# PORTLAND MAINE

November 23, 2004

Re: Building Permit #041652

A review of the submission for the conversion of the S-1 (Morin's Garage) use group to an A-2 (Nightclub) use group has commenced. The review cannot continue until all of the following information is submitted and found to be Code compliant:

MECHANICAL FLOOR PLAN

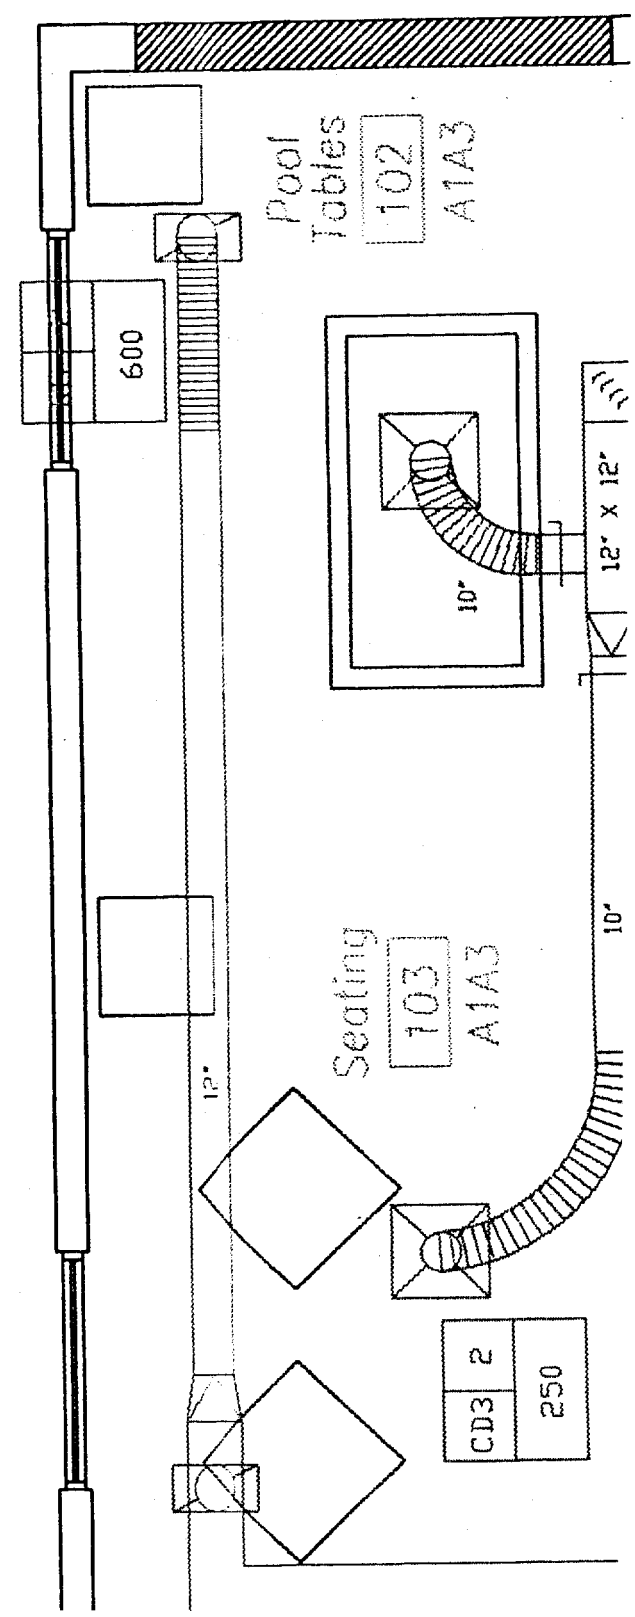
- 1) HVAC equipment and duct plans to provide ventilation for this use as required by the Mechanical code. These plans must include accommodations for additional equipment loads on existing structural members. If this condition exists, an engineer must perform this evaluation

1 Stair Section  
Scale: 1 = 1'-0"

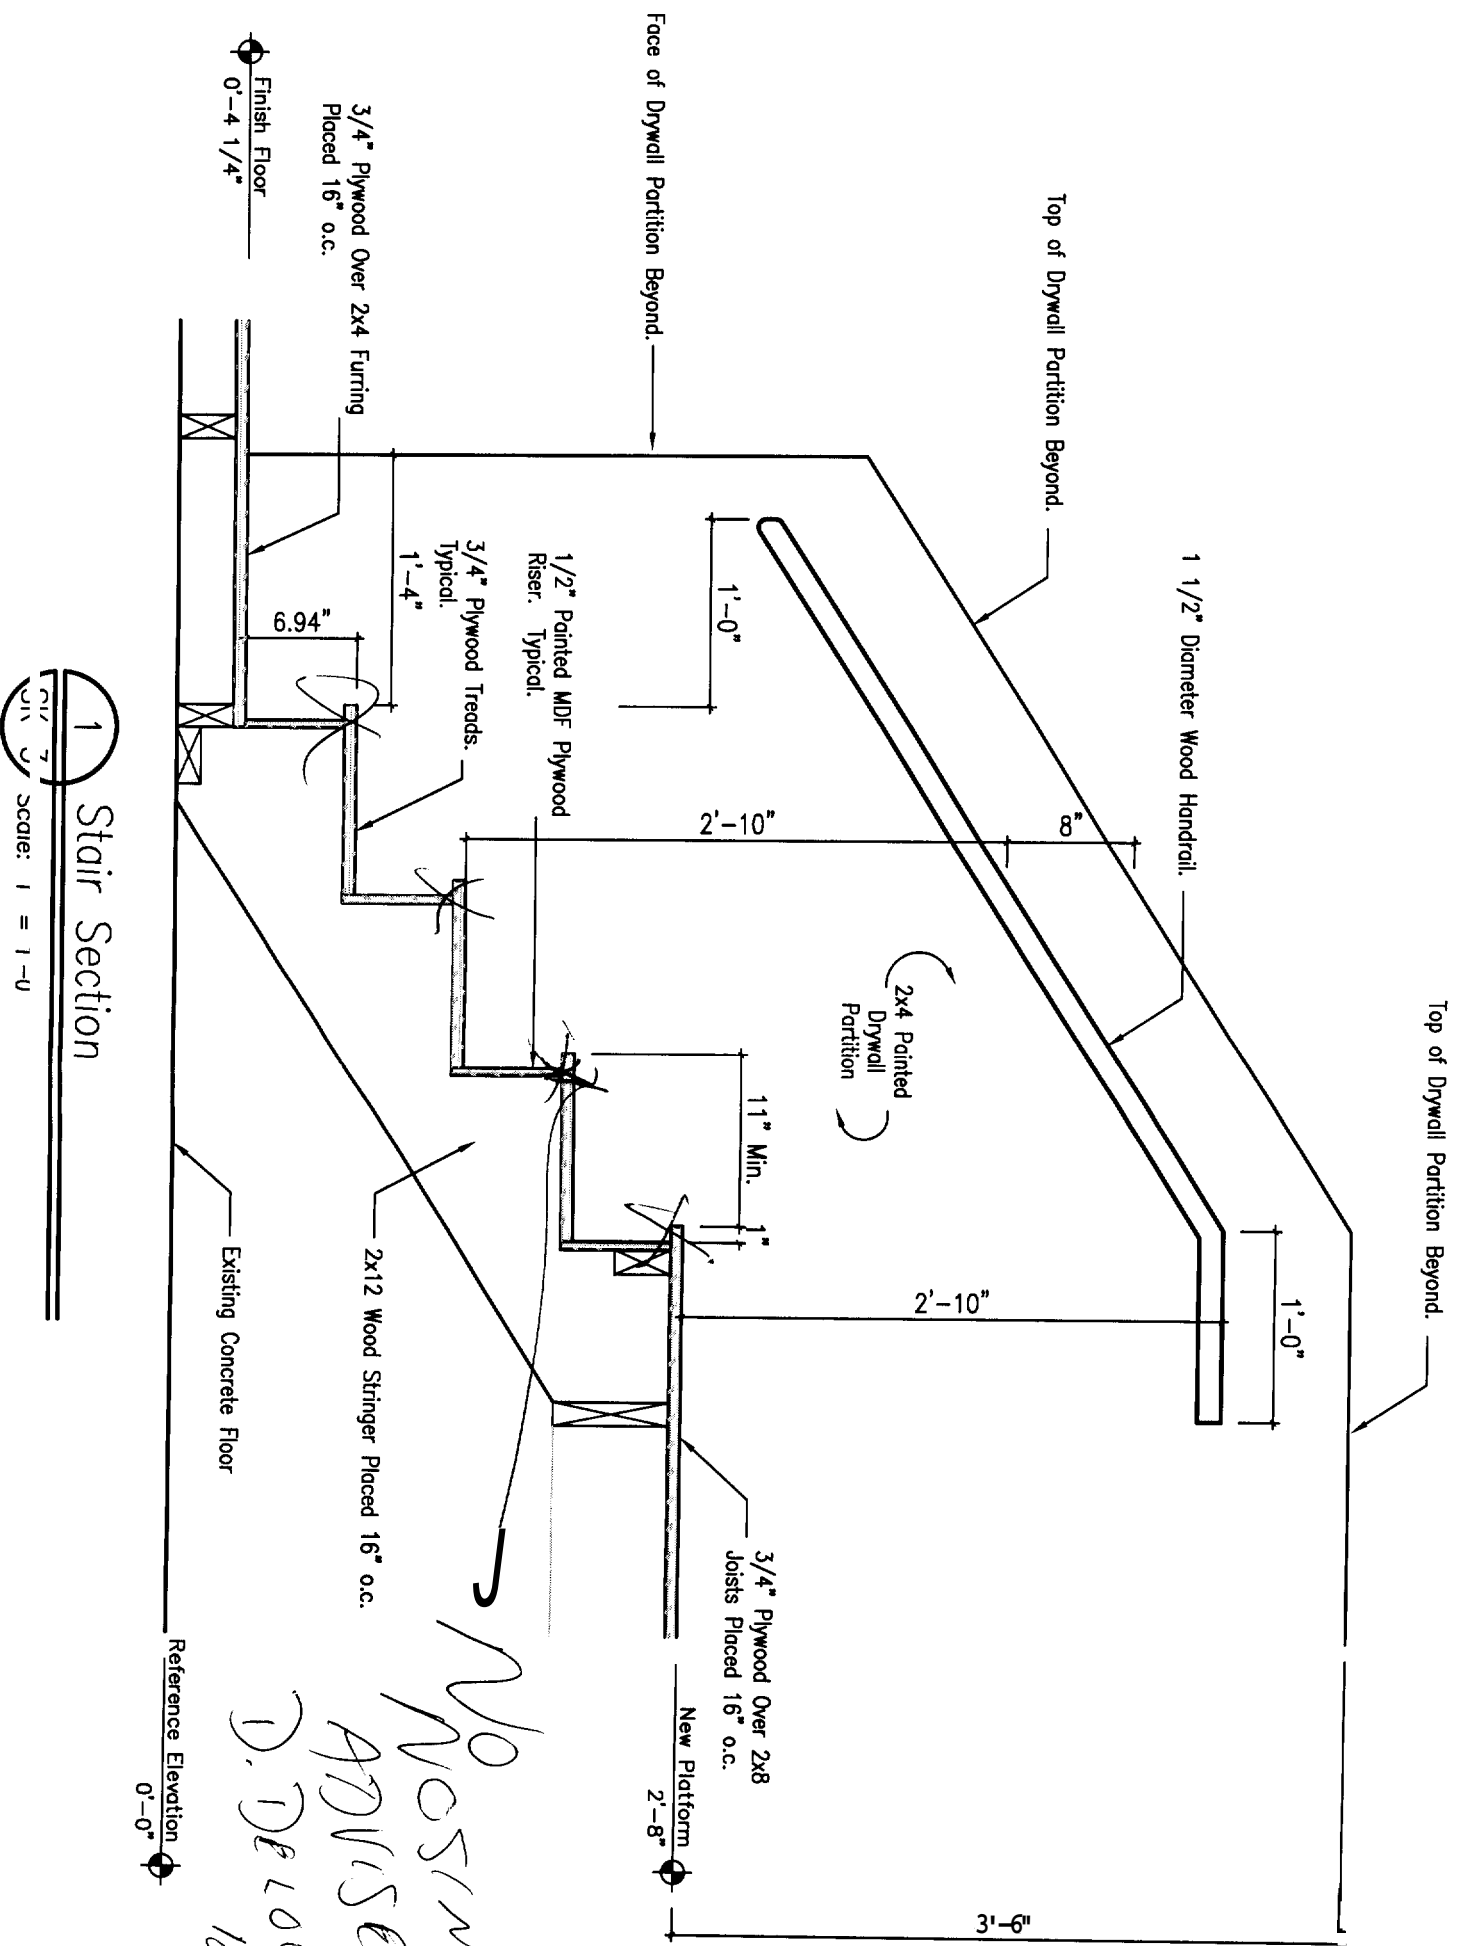
- 4) There is no structural detail for the stairway.
- 5) Please provide additional information for the masonry infill sections that shows anchoring and rebar schedules.
